From: Brian Banister [REDACTED]
Sent: 14 April 2026 15:24
To: Planning.Responses <Planning.Responses@arun.gov.uk>
Subject: Arun Conservation Area Advisory Panel comments on applications

Hello,
The **Arun Conservation Area Advisory Panel** wish the following comments to be taken into account in the determination of the applications:

LU/67/26/HH - 5 Old Warehouse Mews, Western Road, Littlehampton

Client: Mrs s. Baker, 5 The Old Warehouse Mews, Littlehampton BN17 5GE		Revision	Date	Description
Project: Window Replacement		Scale:	Date:	Drawn By:
Drawing Title: Proposed PVC Windows		1:20	-	BE
		Drawing Number:	1733/004	Revision: -

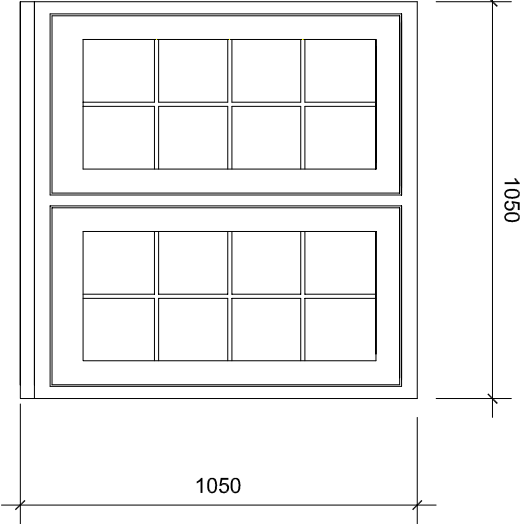
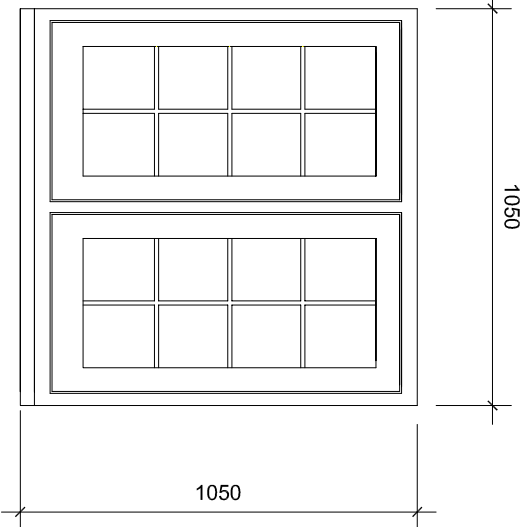
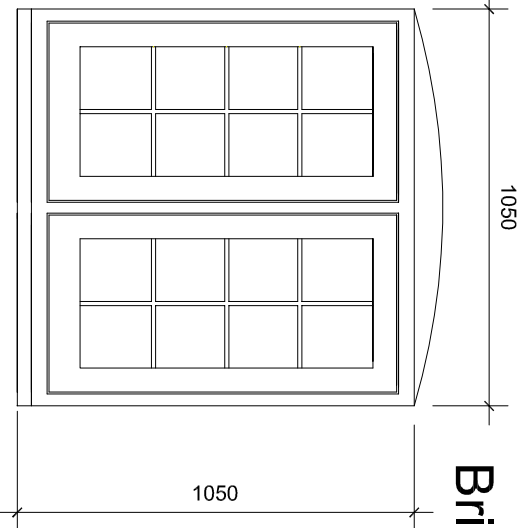
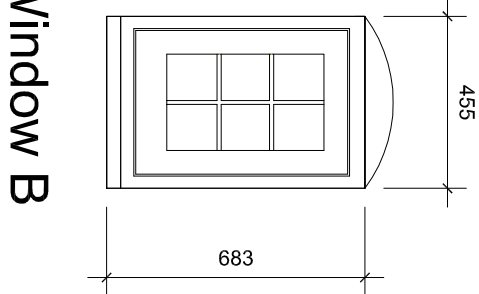
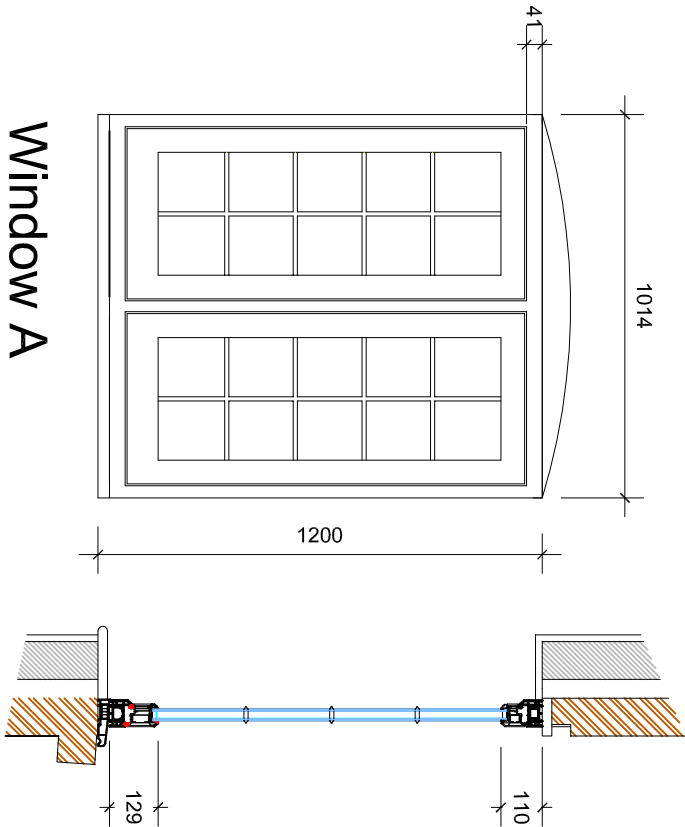
Objection

It is generally accepted that the use of Pvcu fenestration in the historic environment is not appropriate. This is because it lacks the subtlety of proportion, surface texture and convincing details such as properly formed glazing bars.

It is appreciated that there may be some examples of Pvcu fenestration nearby but that should in no way set a precedent for the wider use of an inappropriate material which, if approved, would further detract from the special character and appearance of the conservation area. There will also be an impact on the settings of several nearby Listed Buildings and structures, namely 34,36 ,47-51 Western Road, 3, 3a and 4 Norfolk Place; and the garden walls to 7 Norfolk Place and east of 51 Western Road. 7 Norfolk Road is included in the Council's Local List.

As such, the Panel consider that the proposal will conflict with the relevant paragraphs of the NPPF and policies contained in the ADLP relating to the protection of designated and non-designated heritage assets and their settings.
